Engineers Comments Regarding Surface Water Drainage

Application Reference:	P/46/25/DOC	Reviewer Reference:	ADC/SB
Planning Officer:	Jessica Riches	Date of Review:	30/07/2025
Site Name:	Land South of Summer Lane and West of Pagham Road Pagham		
Application Description:	Approval of details reserved by condition imposed under reference P/140/16/OUT relating to condition number 4 - detailed scheme of phasing , condition number 5 - schedule of materials and finishes, condition number 17 - Construction Management Plan and condition number 24 - energy.		
Assessment Number:	1 of 2

Condition 4: Objection

DRAWING TITLE
**Pagham
Site Phasing Plan**

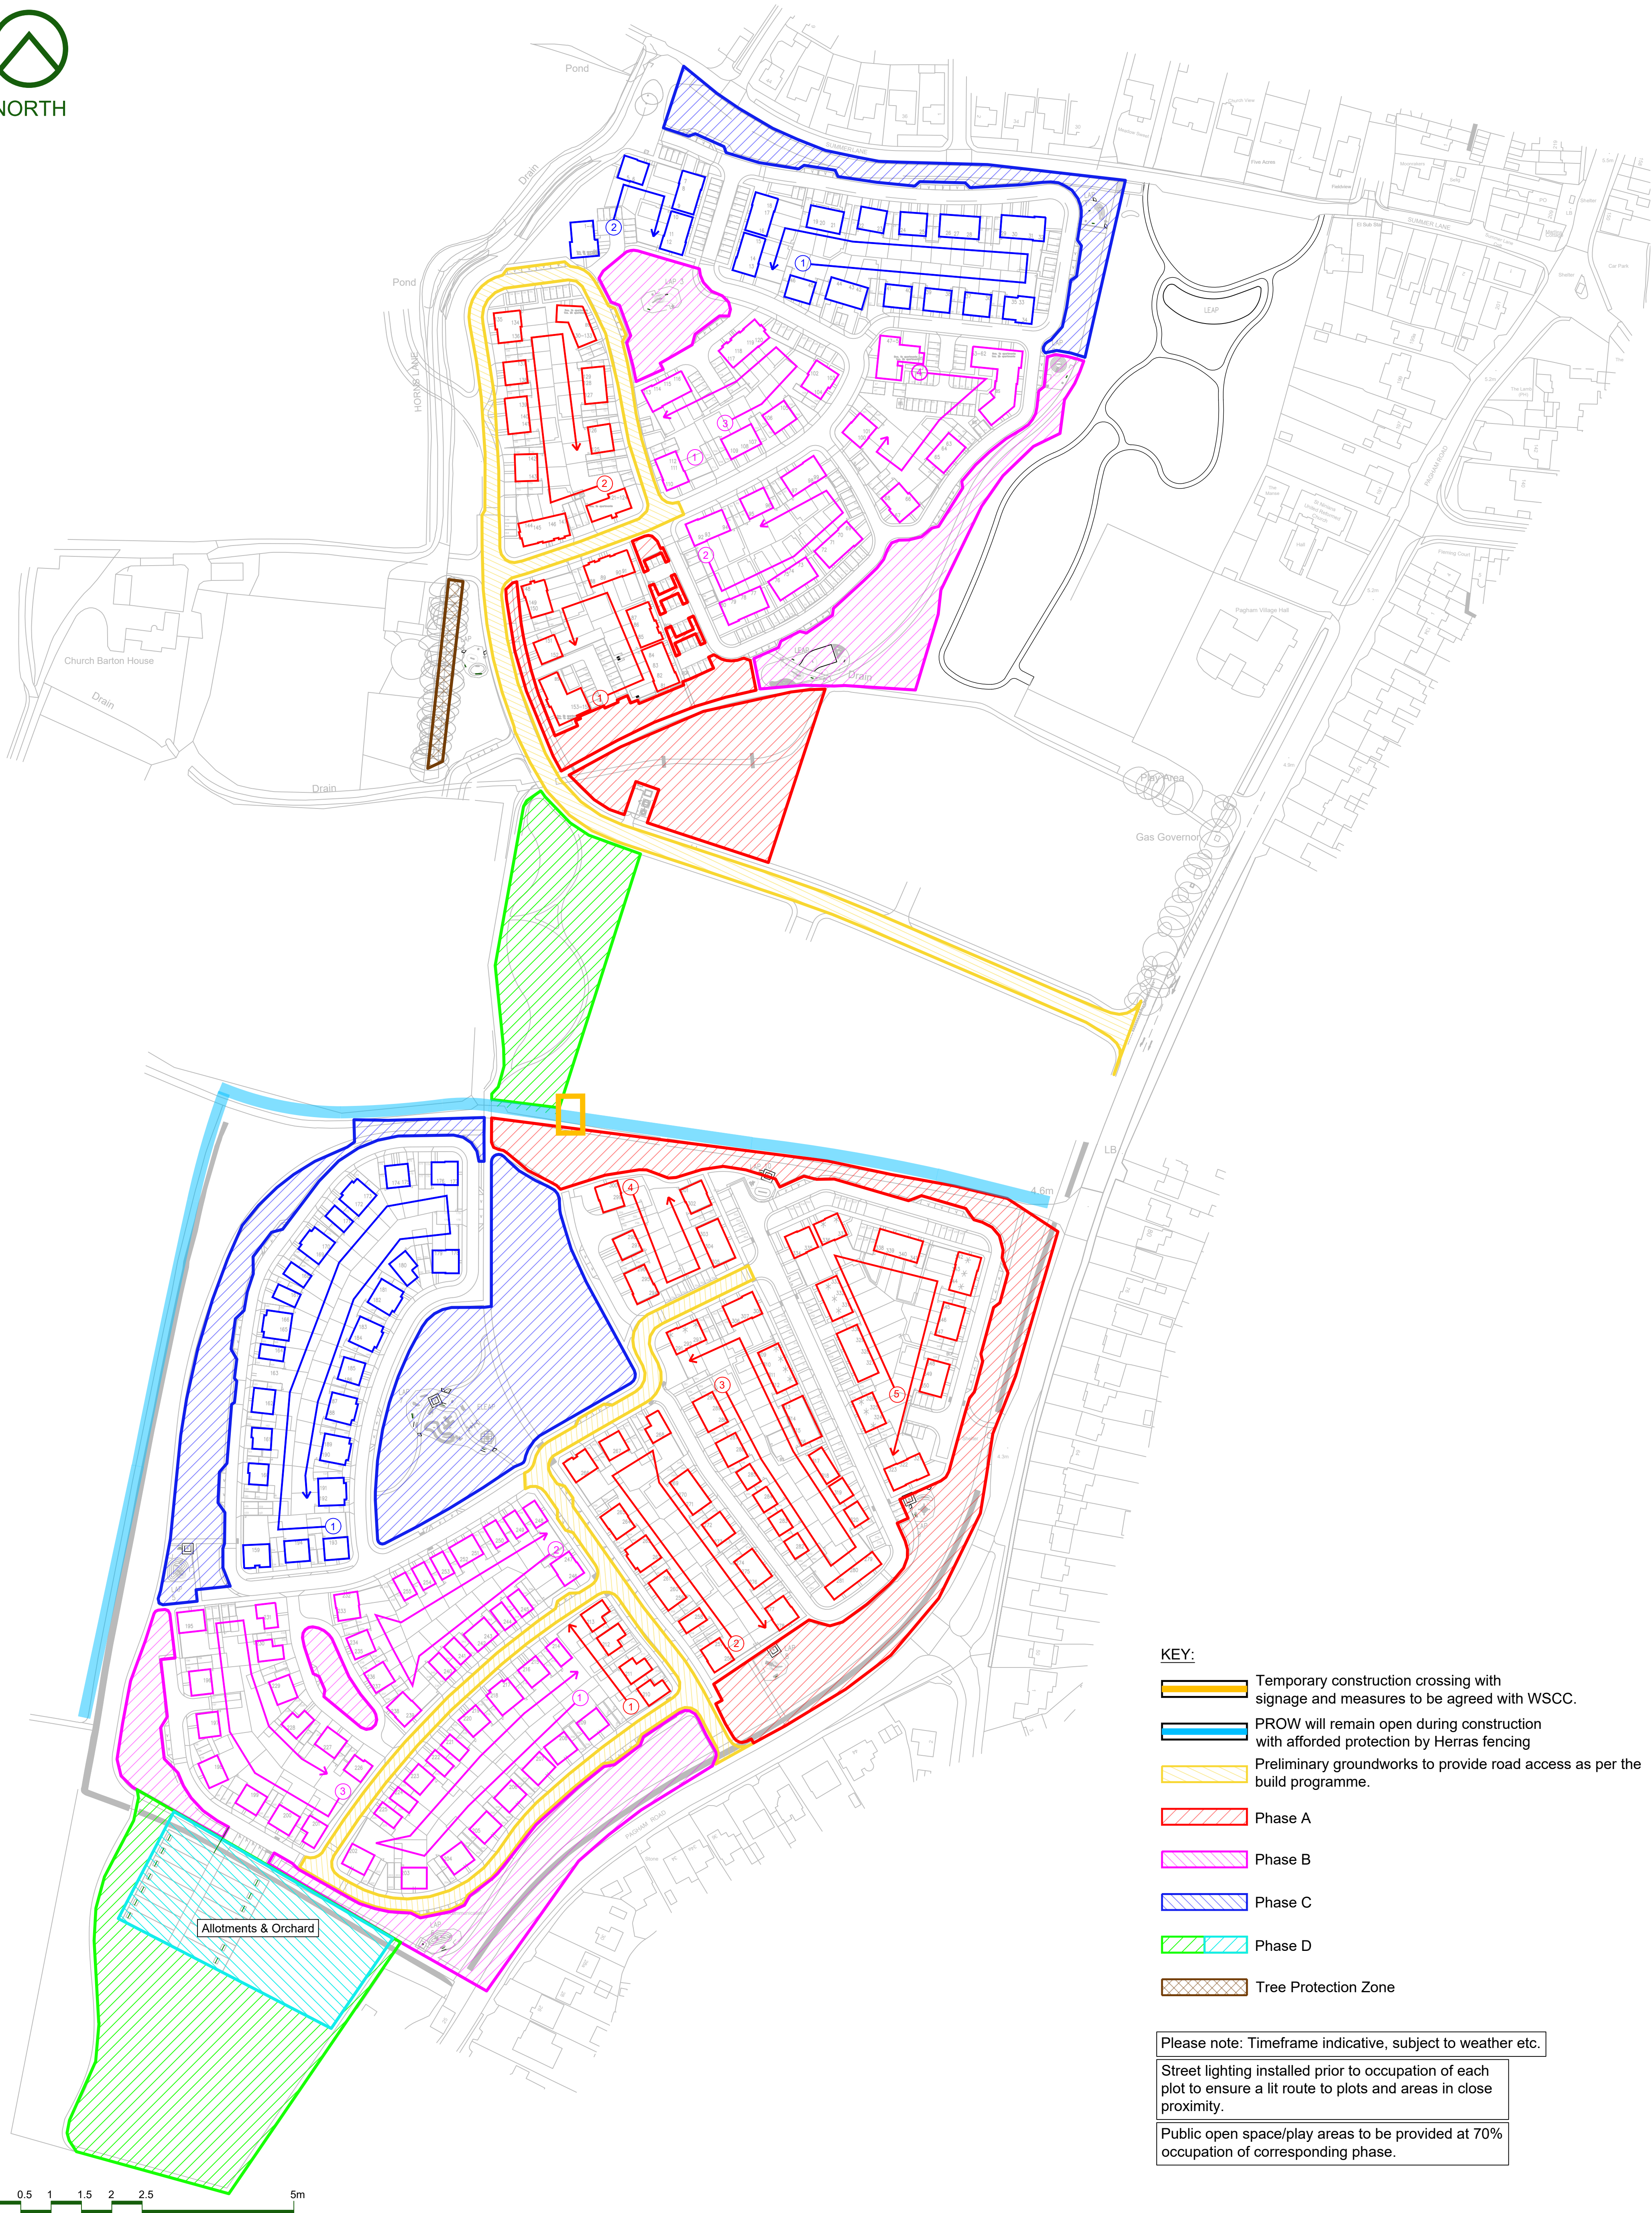
The DPP shows that parts of the preliminary access drainage are reliant on later phases drainage network, storage and outfall. Illustrated in two snips below:

Preliminary access drainage reliant upon Drainage Phase A.

Preliminary access drainage reliant upon Drainage Phase B.

The same plan also shows that two parts of Drainage Phase B are reliant upon the construction of the network, storage and outfall for Drainage Phase C:

Drainage Phase B reliant upon Drainage Phase C.

Drainage Phase A reliant upon Drainage Phase B.

It is unclear why the drainage phases are split between the north and the south. The implication is that both the north and the south will be constructed concurrently with two phases of construction being completed at the same time in different parts of the site. This needs to be clarified, and if the north and south of the site are to be completed in a phased approach then this should be reflected by the plans.

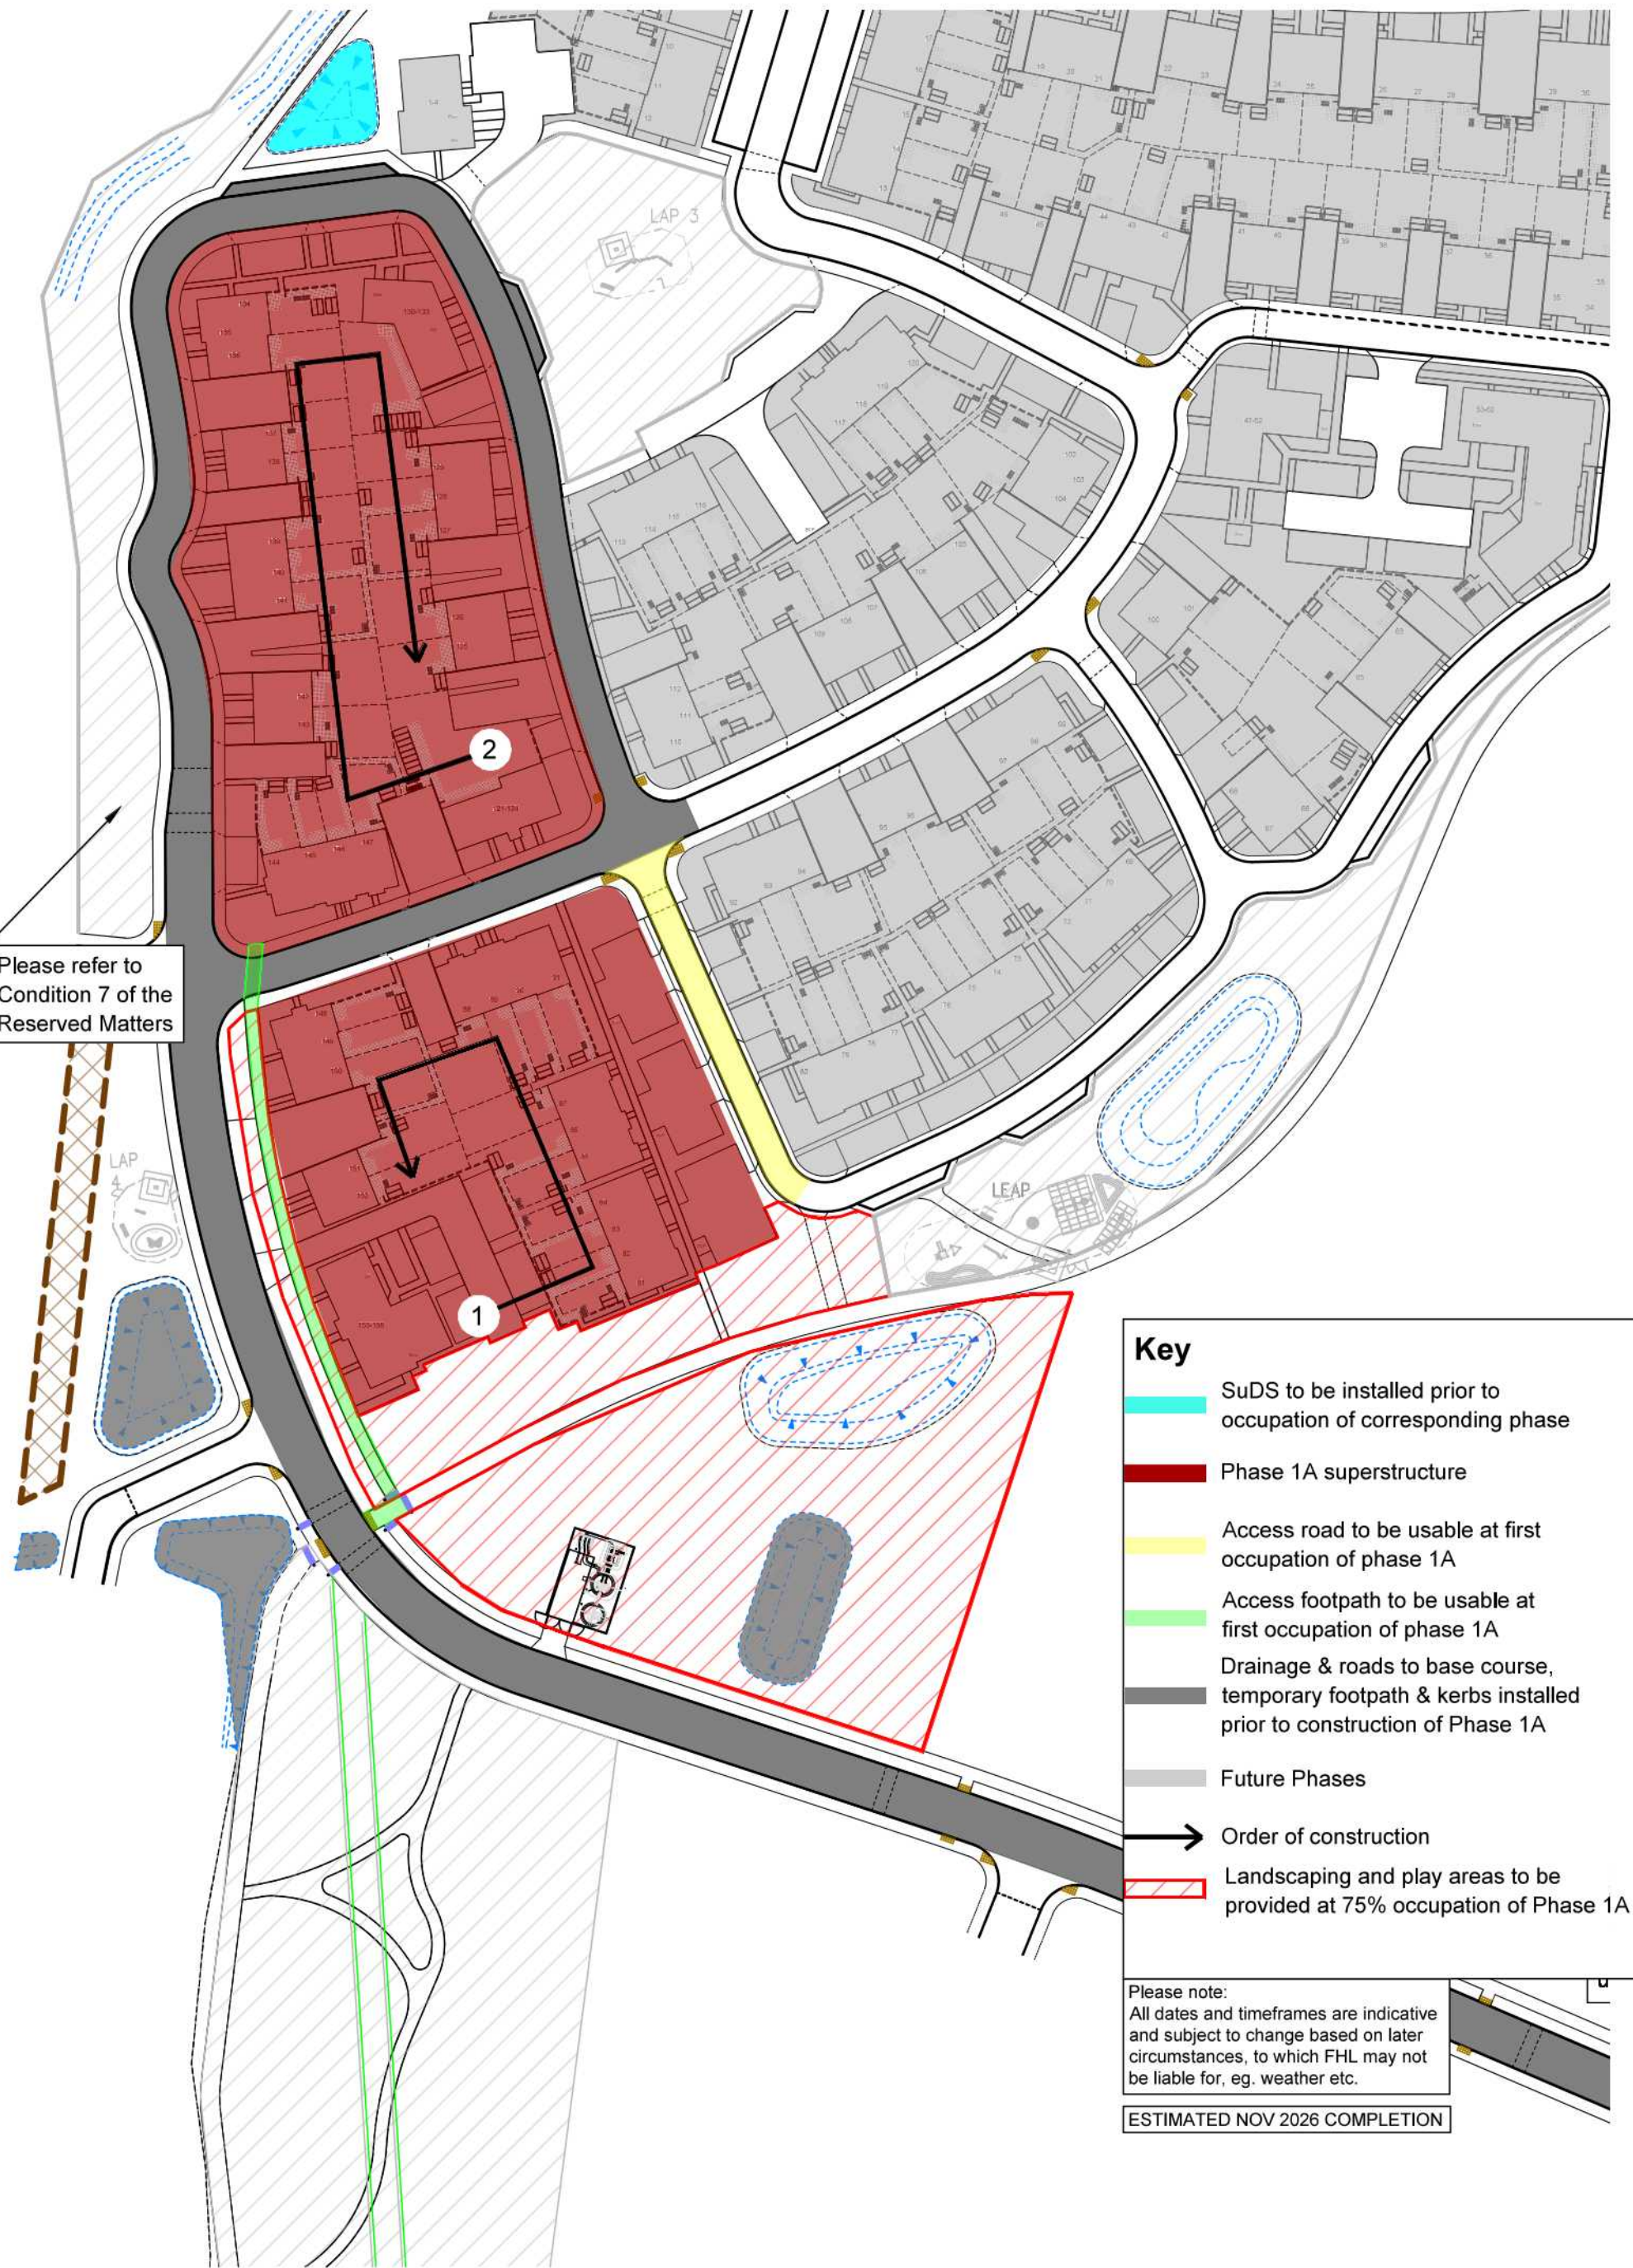
The site phasing plans state that SuDS are to be installed prior to occupation of corresponding phase. This is not acceptable as it could result in significant construction having been completed and inadequately drained as it is not technically occupied. This could lead to an increase in flood risk and pollution during the construction of the site. Temporary drainage to manage flood risk and silt (pollution control) must be constructed prior to any further construction in that phase, then if those temporary drainage features are to be permanent then they must be remediated prior to occupation of the final dwelling in the phase.
